Town of Addison

Summary of Engineering Review Comments

Date: August 23, 2019
 Plan Review : Civil Review 1
 Received: July 30, 2019
 Plan Date: July 25, 2019
 Development: Galaxy FBO

Town Project #:19-09D

SHEET NUMBER
C04.01

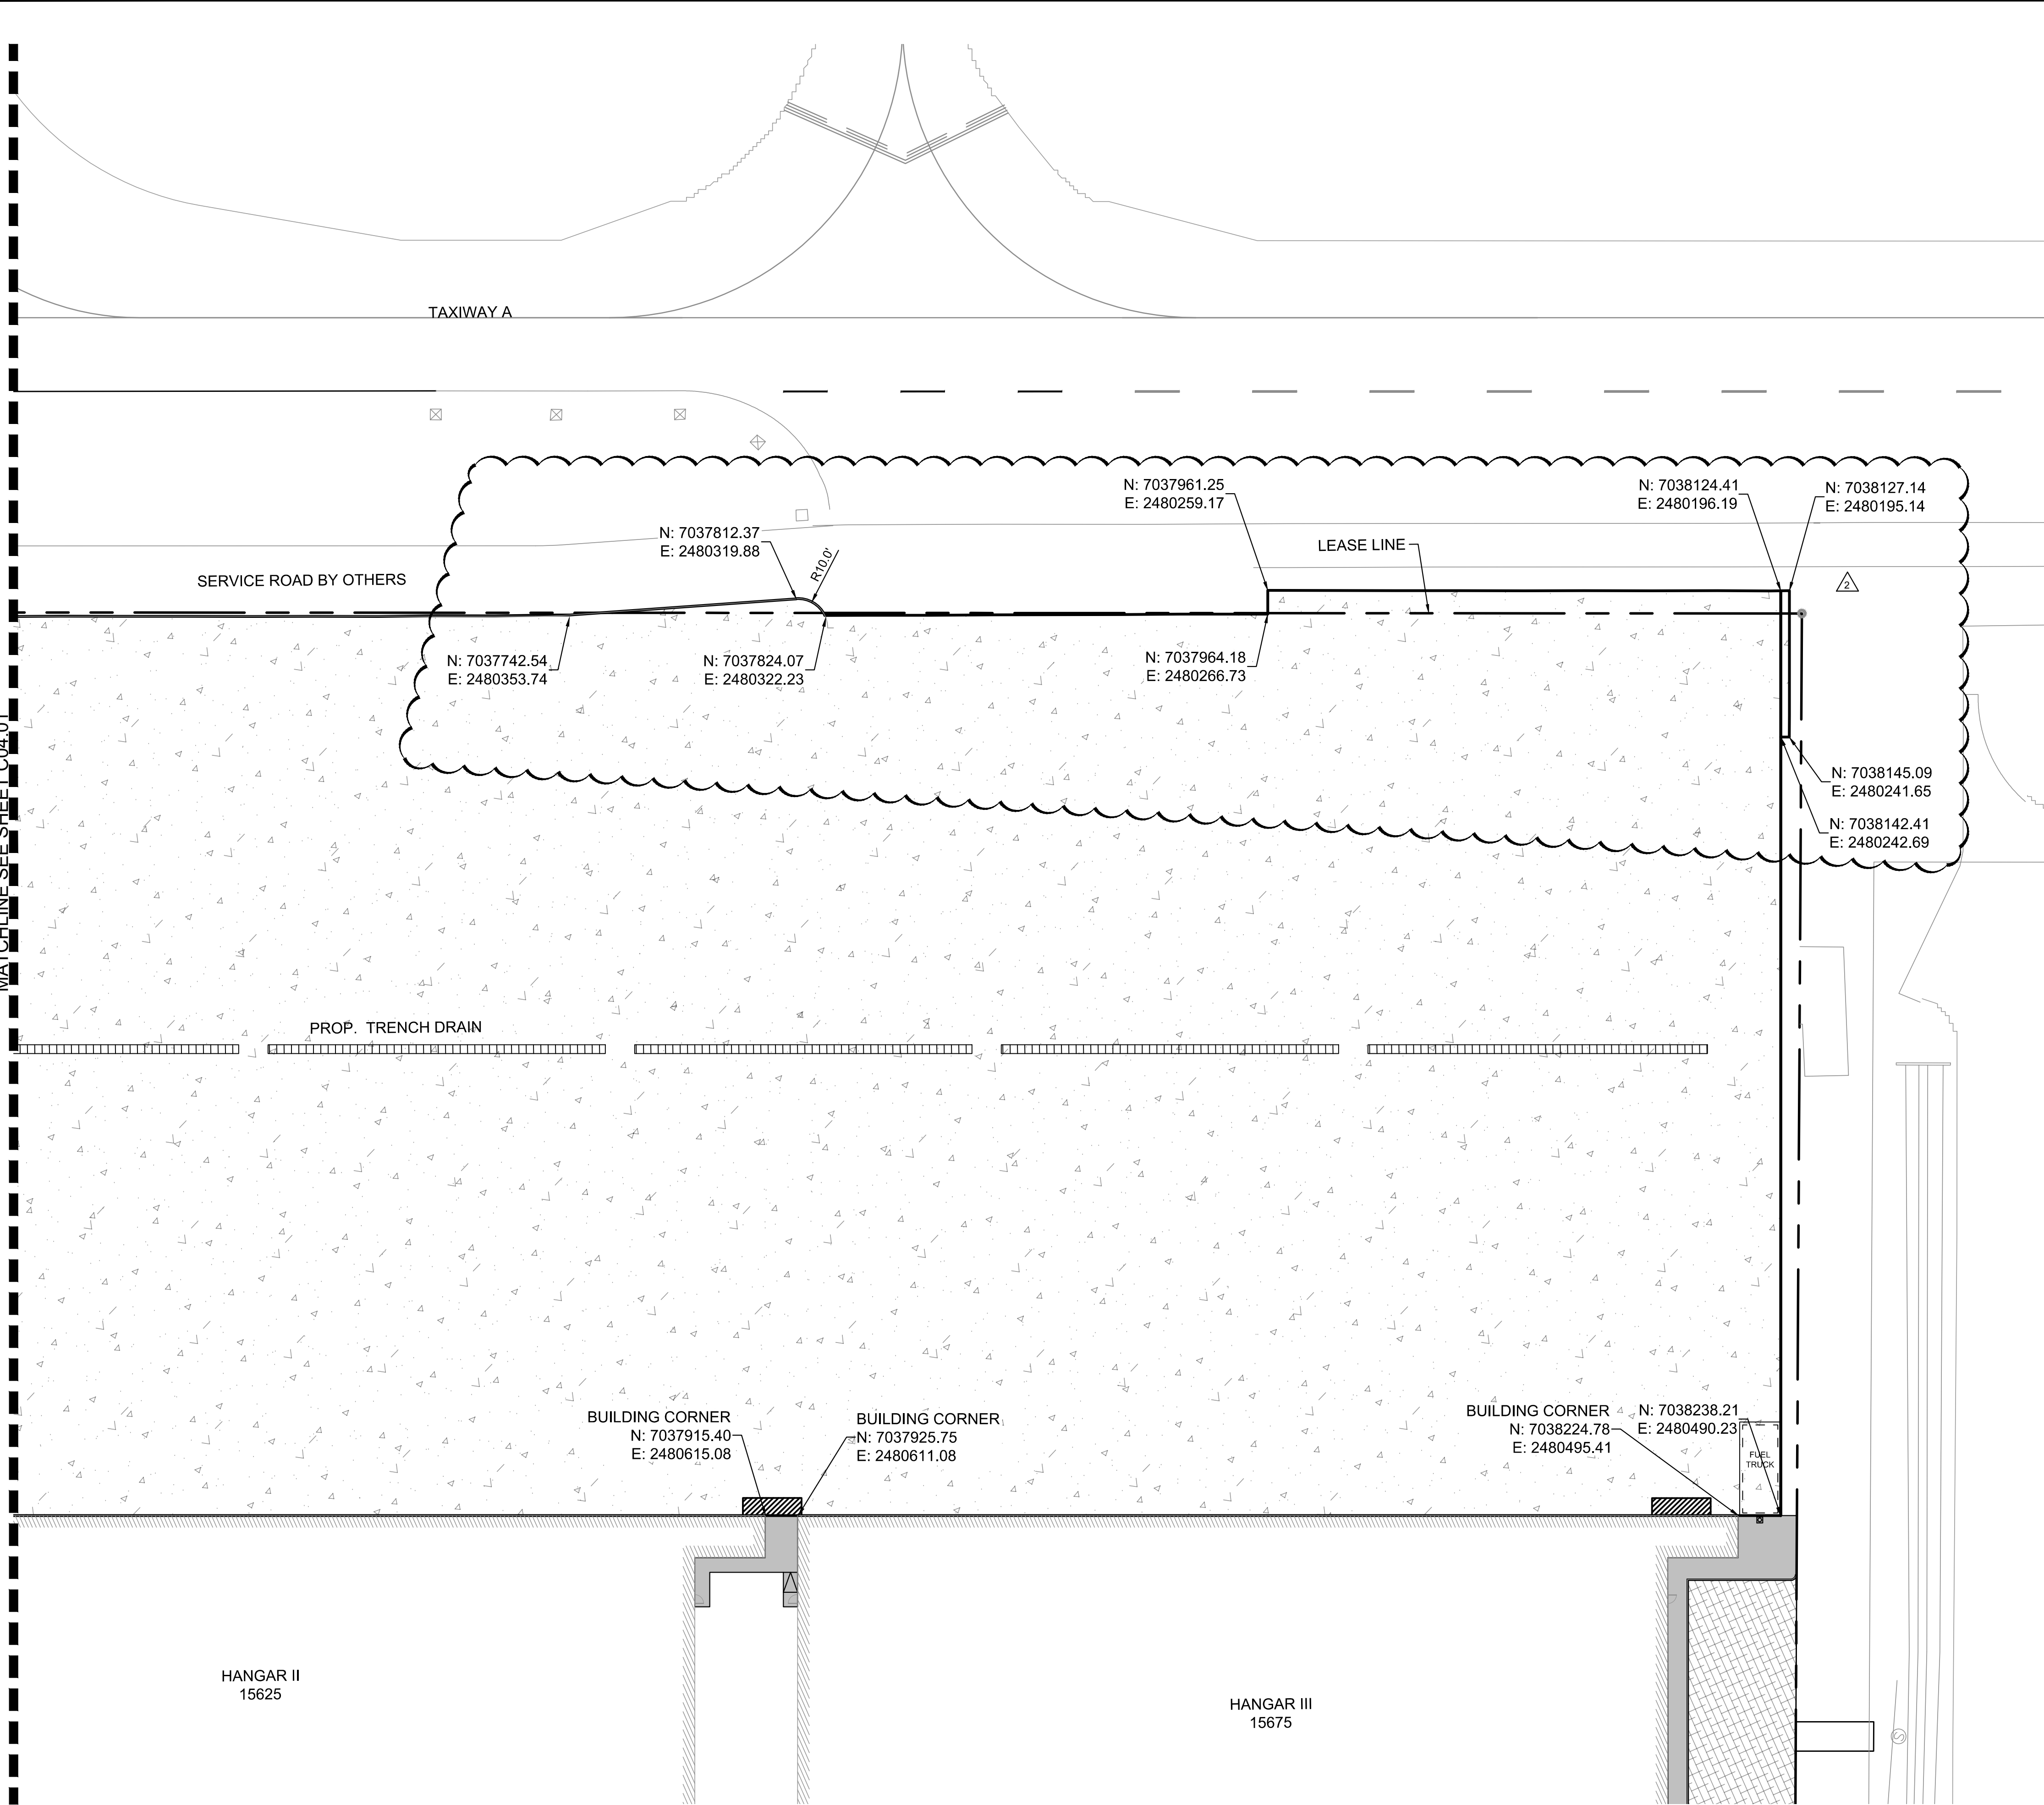
Page No.	Comments	Response (See Note)	Explanation
C04.01	Where is the new access road? Show location & connection to it.	DISAGREE	ACCESS ROAD PROVIDED BY OTHERS
C04.03	Call for 1" expansion joint on details 3 & 5	AGREE	
C05.01	Label all curb curve radii	AGREE	
C05.01	Add detail nomenclature to the legend (typ)	AGREE	
C05.01 & 05.05	Light duty pavement called out in the legend doesn't match the pavement detail. Should call for medium duty. (typ)	AGREE	
C05.01	Transition sidewalk to match existing at the southern property line.	DISAGREE	THE PROPOSED SIDEWALK IS TIEING INTO THE EXISTING CURB AT A 90. THIS WILL BE BEST FOR FUTURE TIE-IN, AS THERE WILL NOT BE ANY ADDITIONAL SIDEWALK REMOVAL NEEDED.
C05.01	Should be 5" sidewalk. (typ)	AGREE	
C05.02	What is the darker cross-hatched area? It is not labeled or in the legend. If it is pedestrian accessible, it should have ramps.	DISAGREE	THIS AREA IS FOR LANDSCAPE ONLY, IT IS NOT A SIDEWALK

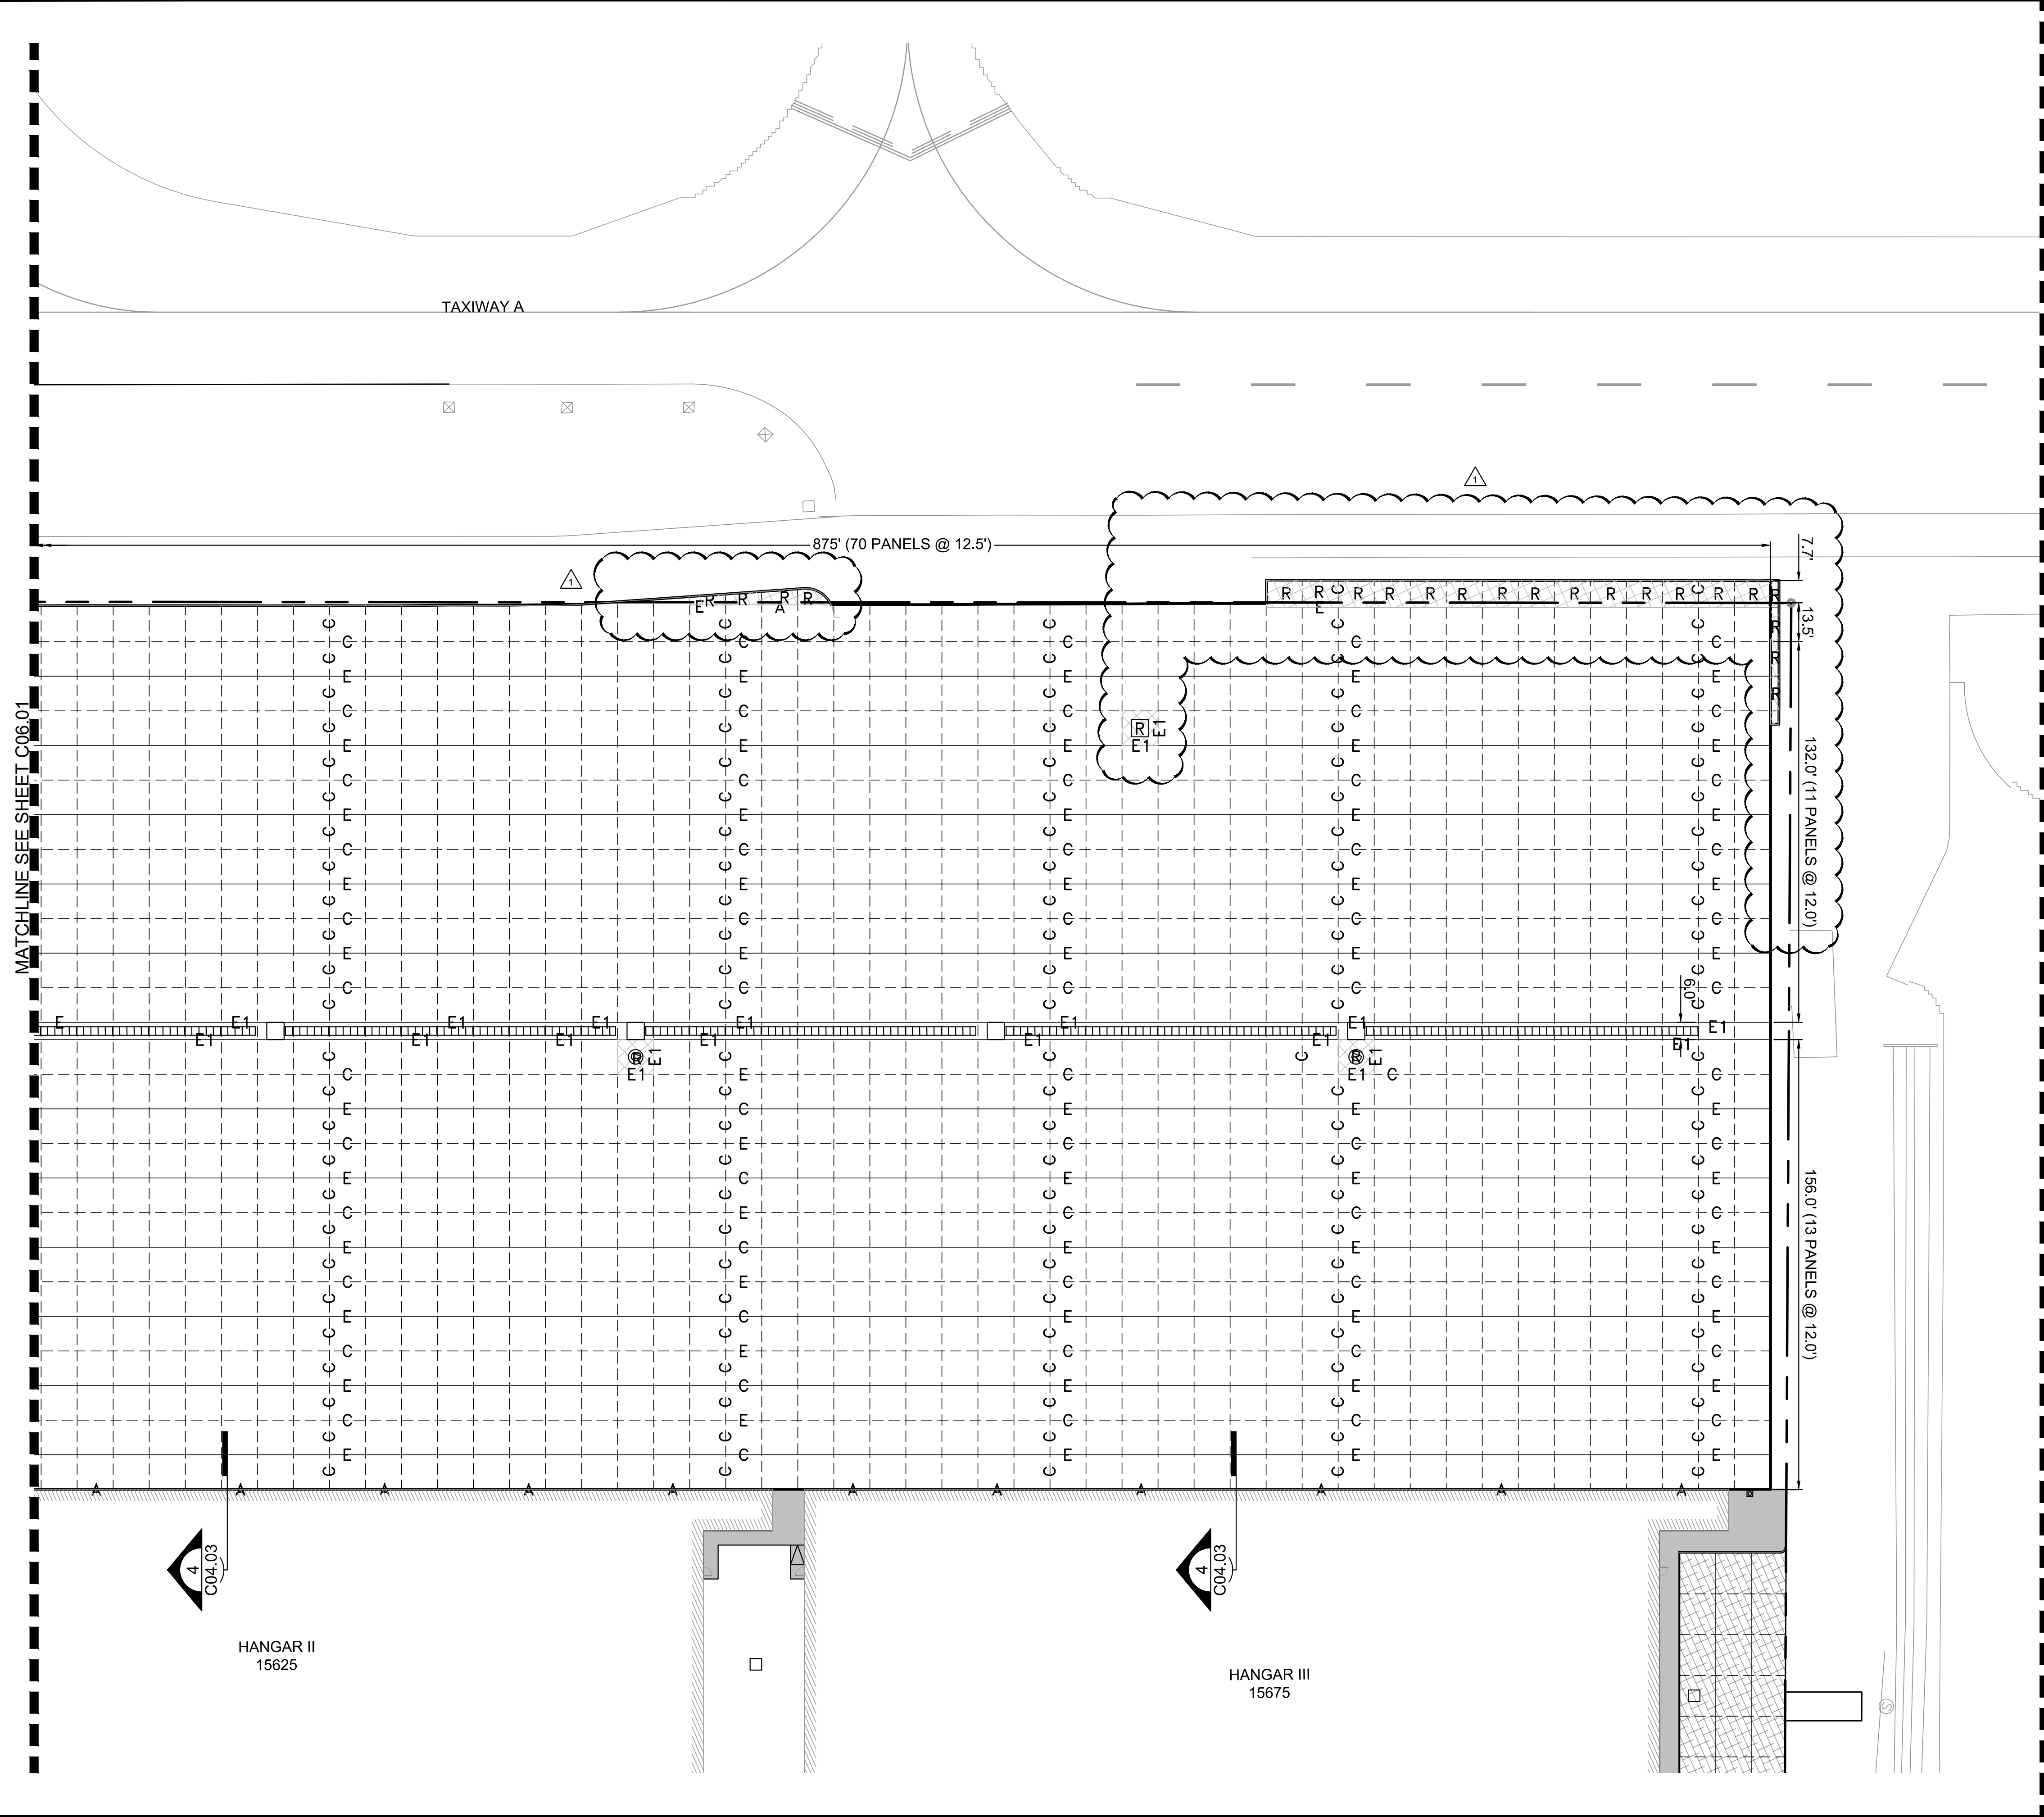
C06.02	Check legend - looks like the isolation & expansion joints may be switched? (typ)	AGREE	
C06.03	Detail 8 should be expansion joint, not isolation joint - has a dowel.	AGREE	
C07.01 & 07.02	Dimension sawcut	AGREE	
C07.01 & 07.02	Call for concrete to asphalt transitions on both driveways.	AGREE	
GRADING	Add elevations at existing pvmt connections to elevation point sheets	AGREE	
GRADING	Please move the grading plan sheets to immediate follow the elevation point sheets.	AGREE
